**WELWYN HATFIELD BOROUGH COUNCIL
DIRECTORATE OF STRATEGY AND DEVELOPMENT**

DELEGATED APPLICATION

Application No: 6/2016/0729/TPO
Location: 34 Kingsmead, Cuffley, Potters Bar, EN6 4AN
Proposal: Removal of broken limbs from crown and crown reduction by 3.5m lateral length on north side of Oak tree covered by TPO 3
Officer: Miss M Hill

Tree location plan received and dated 4 April 2016.

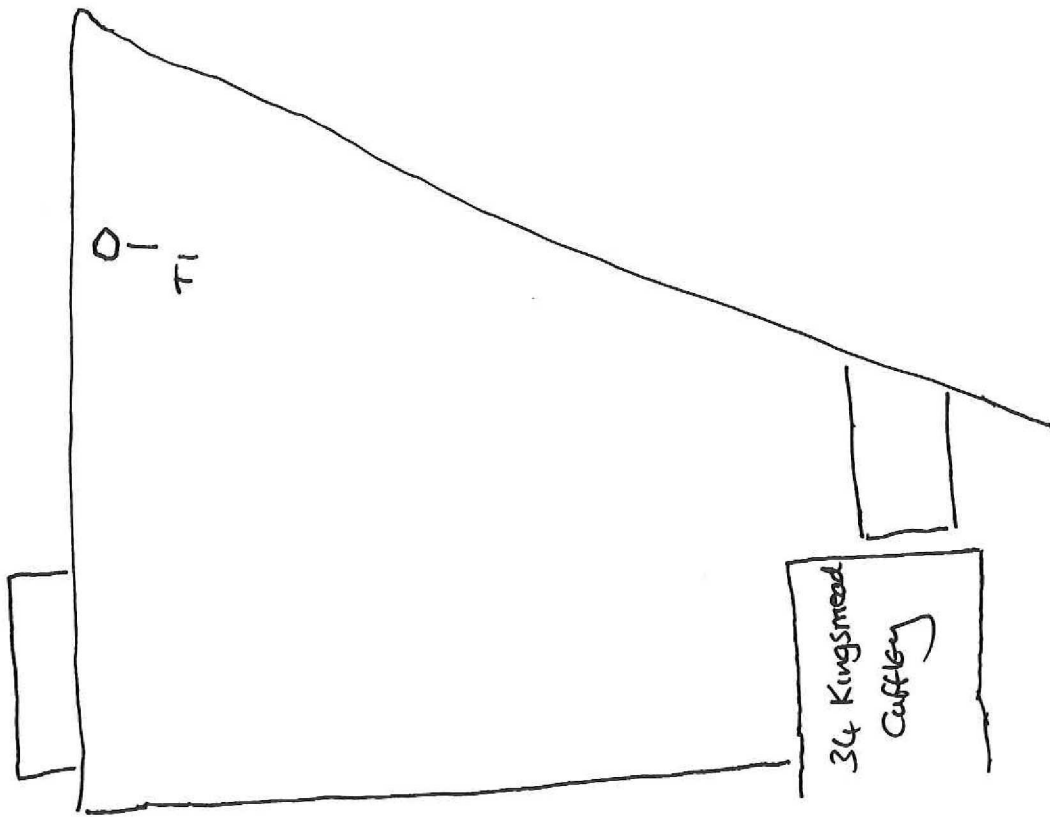
Context	
Relevant history	S6/2013/0665/TP - Remove 2m overhang from Oak T4 covered by TPO 3 - Refused
Main Issues	
Appropriateness of the works in relation to the tree(s)	<p>The mature oak tree stands within the garden of 34 Kingsmead but the application centres on the northern side of the crown which overhangs 4 Orchard Close.</p> <p>The tree appears to have good health and vitality. The structural condition is unknown and does not affect the outcome of the application. The crowns profile appears ragged with the northern branches longer than those over 34's garden which have possibly had some management or storm damage in the past.</p> <p>The proposal is to trim back the overhang. The proposed amount to remove is quite large, however due to the crowns unusual shape, the amount would even it up.</p>
Conclusion	
The proposal to crown reduce by 3.5m lateral length on north side is reasonable arboricultural management and will not detrimentally harm the tree's amenity.

3. The crown reduction by 3.5m lateral length on northern side shall be to suitable fork/branch unions and create a pruning wound no larger than 20cm in diameter.
